Application No: BR/232/24/HH
Site Address: 11 Chichester Road Bognor Regis PO21 2XG
Description of works: Proposed loft conversion. Adjustments to the fenestration.

OWQC73098

11 CHICHESTER ROAD  
BOGNOR REGIS  
PO21 2XG  
PROPOSED PLANS AND ELEVATIONS  
(SC. 1:100 @ A3)  
DRAWING NO: PL 304  
NOV 2024

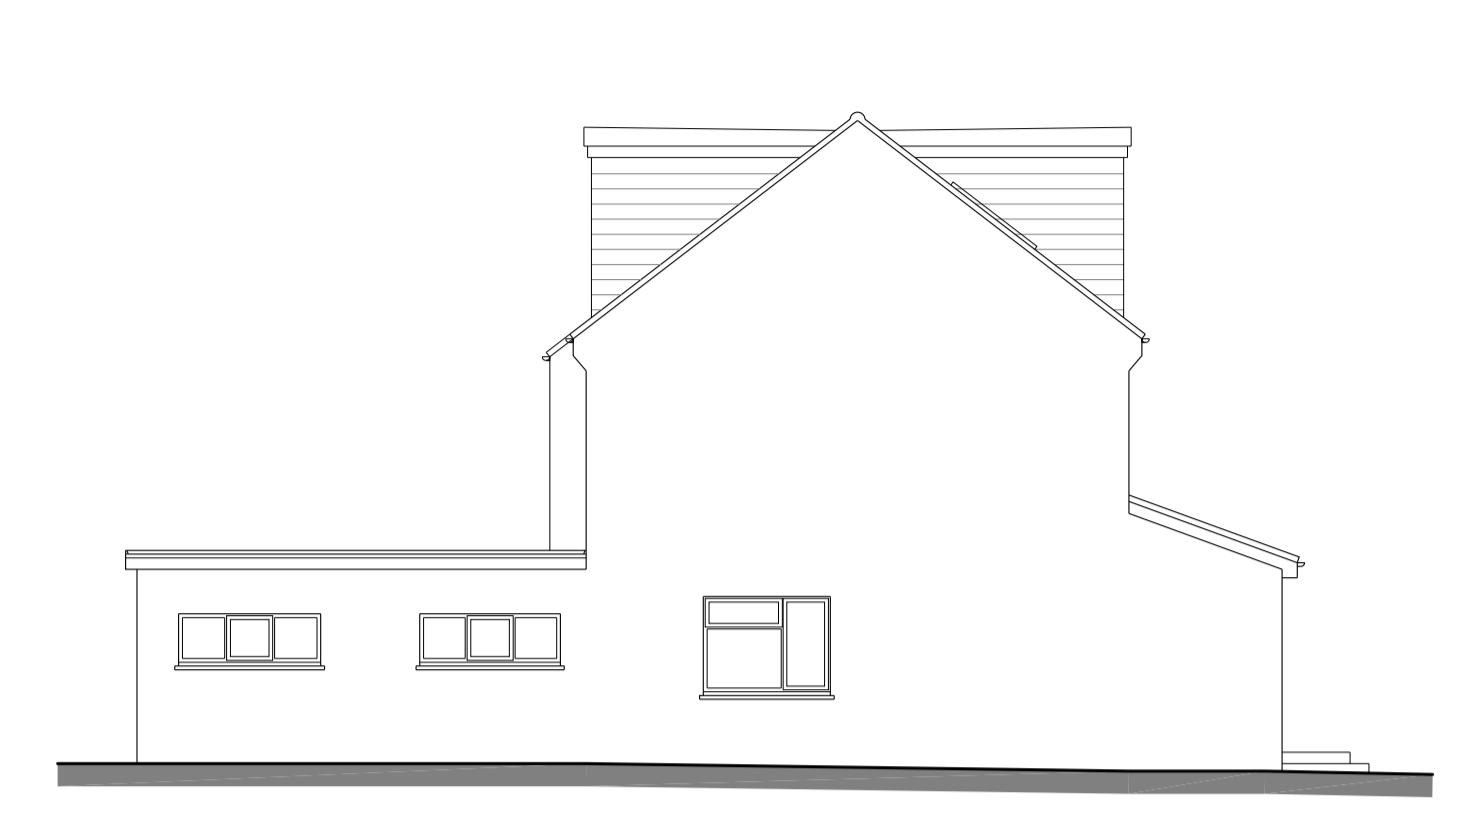
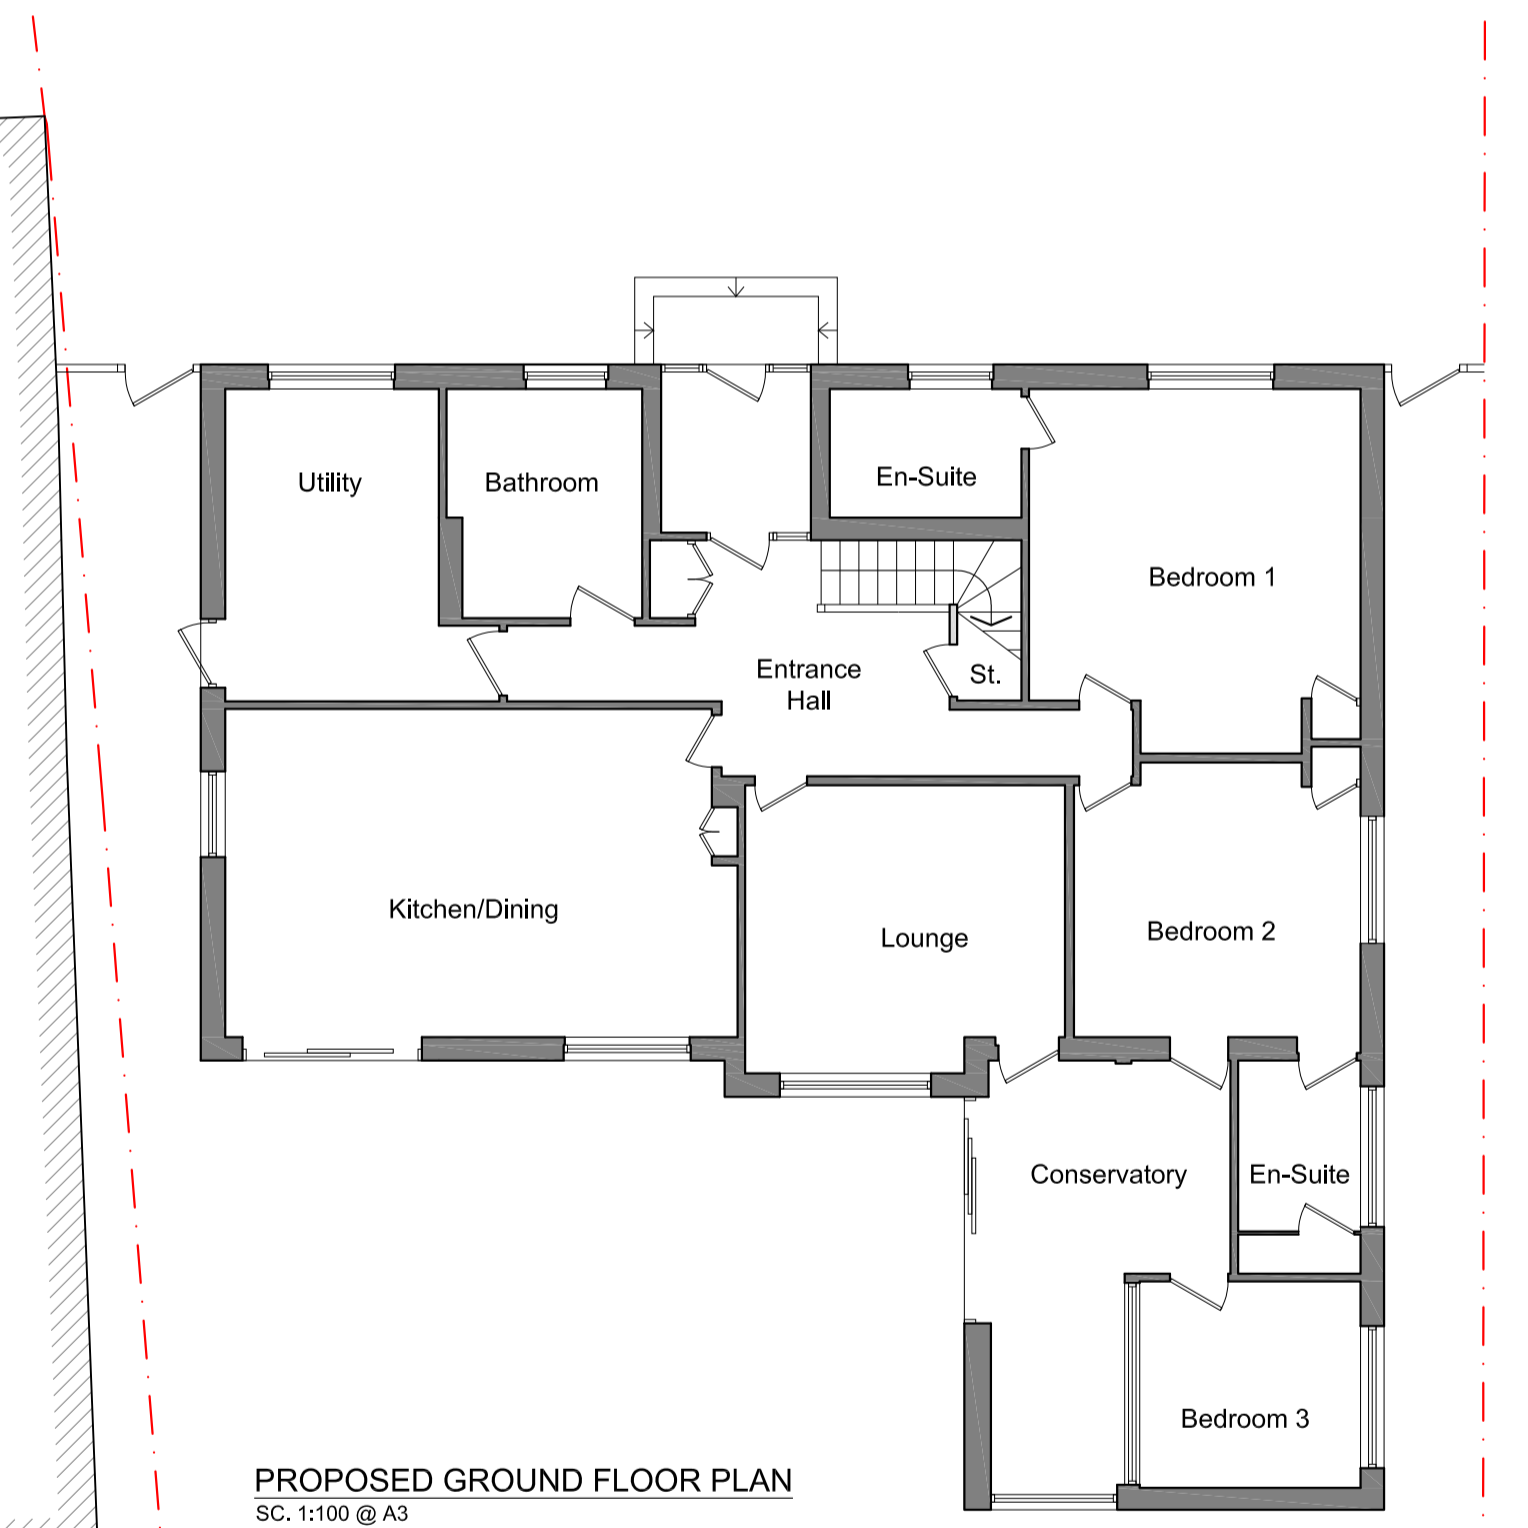
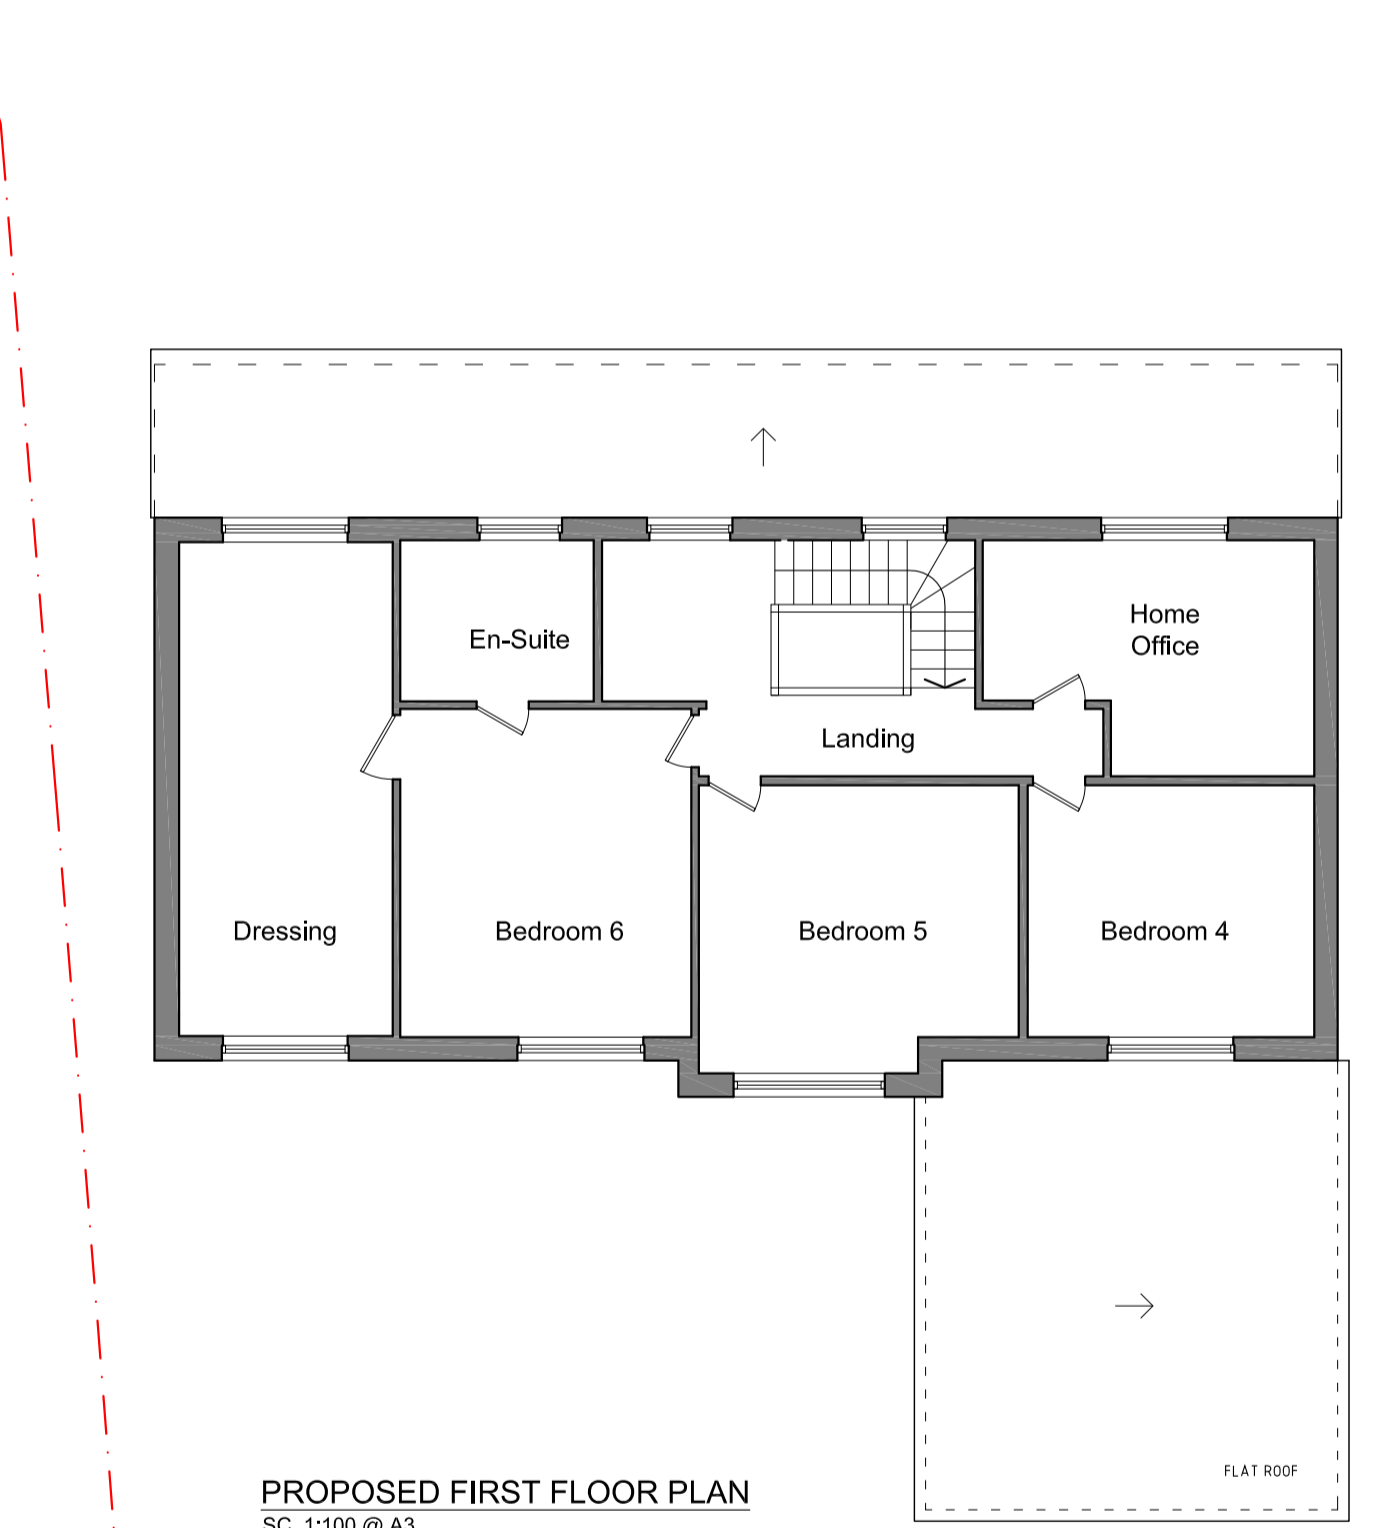
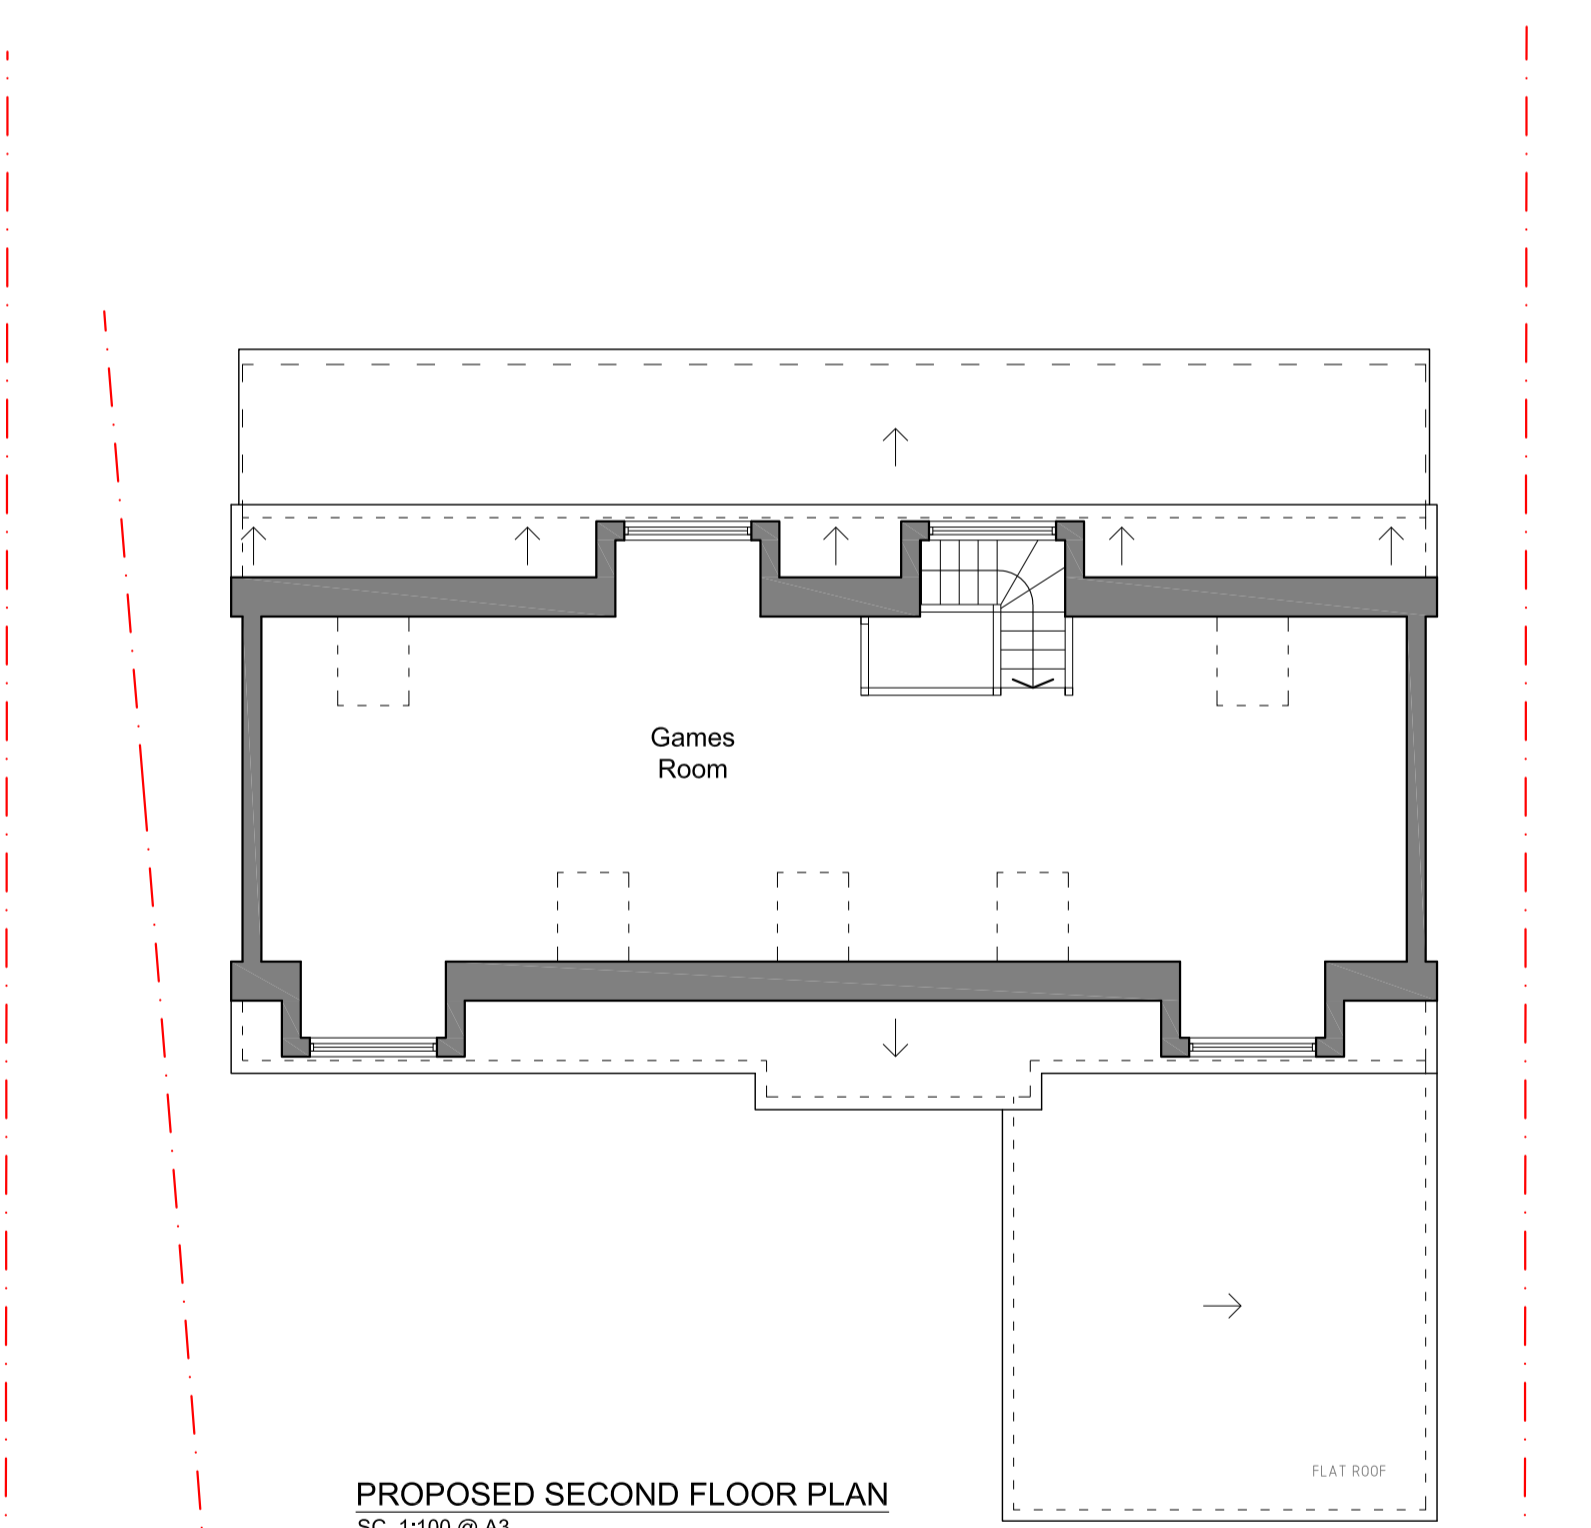
OBJECTION The scale and height of the building, with the addition of dormers to the rear, are such that it has unneighbourly and significantly adverse impacts on the amenities of the occupiers of the neighbouring property to the east (81 Annandale Avenue) by way of appearing overbearing and oppressive in contradiction with Policies D DM1 and QE SP1 of the Arun Local Plan.
